Ruth King,
Mirfield Designs
28, Chadwick Lane
Lower Hopton
Mirfield
WF14 8RAKirklees Direct
Tel: 01484 414746
Email: molly.storer@kirklees.gov.ukDate: 22-Feb-2024
Our Ref: 2024/90069

TOWN AND COUNTRY PLANNING ACT 1990
TOWN AND COUNTRY PLANNING (GENERAL PERMITTED DEVELOPMENT) (ENGLAND)
ORDER 2015 – SCHEDULE 2, PART 1, CLASS A.1 (g)
AT: 14, Lincroft Avenue, Dalton, Huddersfield, HD5 8DS
Prior notification for single storey rear extension

The Authority has considered your application, and it has been determined that the proposal is not acceptable and prior approval is hereby **Refused** for the following reason(s):-

Client Mr Smith					
Job 14 Lincroft Avenue Huddersfield					
Title Proposed floor plan					
Drawn By RK	Date Oct 2023				
Eng. Check	Scale 1:200, 100				
Tech. Check					
Drawing No. 2023 / 434 / 02	Rev. <table> <tr><td> </td><td> </td></tr> <tr><td> </td><td> </td></tr> </table>

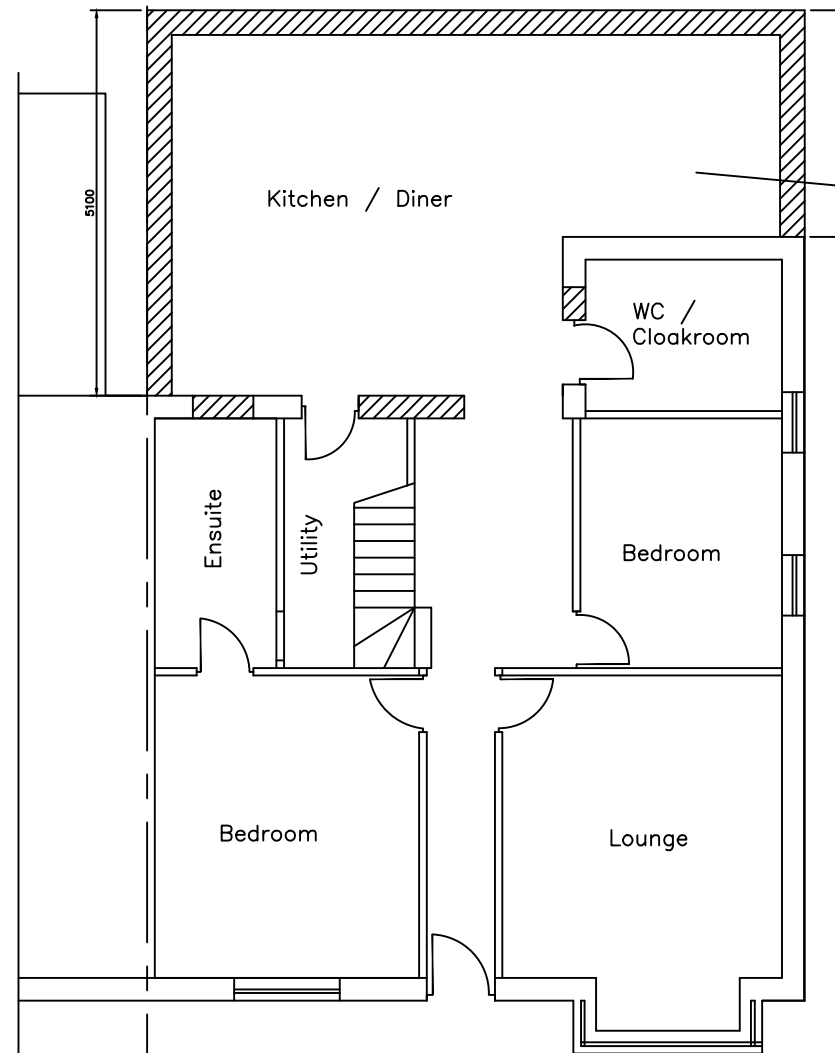
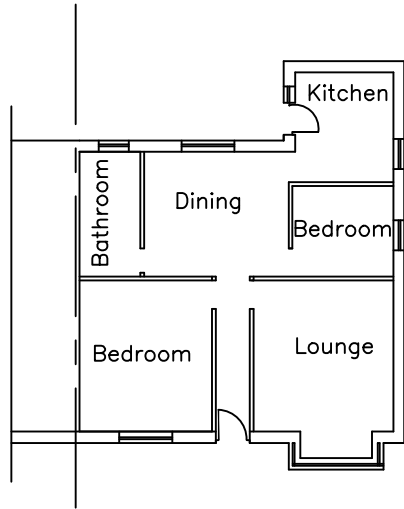
The proposal is for erection of single storey rear extension. The extension projects 5.1m beyond the rear wall of the original dwellinghouse. The maximum height of the extension is 3m, the height of the eaves of the extension is 2.8m

The proposed enlargement does not benefit from a general planning permission under Article 3(1) and Class A, Part 1 of Schedule 2 of the Town and Country Planning (General Permitted Development) (England) Order 2015 as the rear projection also extends beyond a side wall of the original dwellinghouse and has a width greater than half the width of the original dwellinghouse contrary to sub-paragraph (j) of Class A.
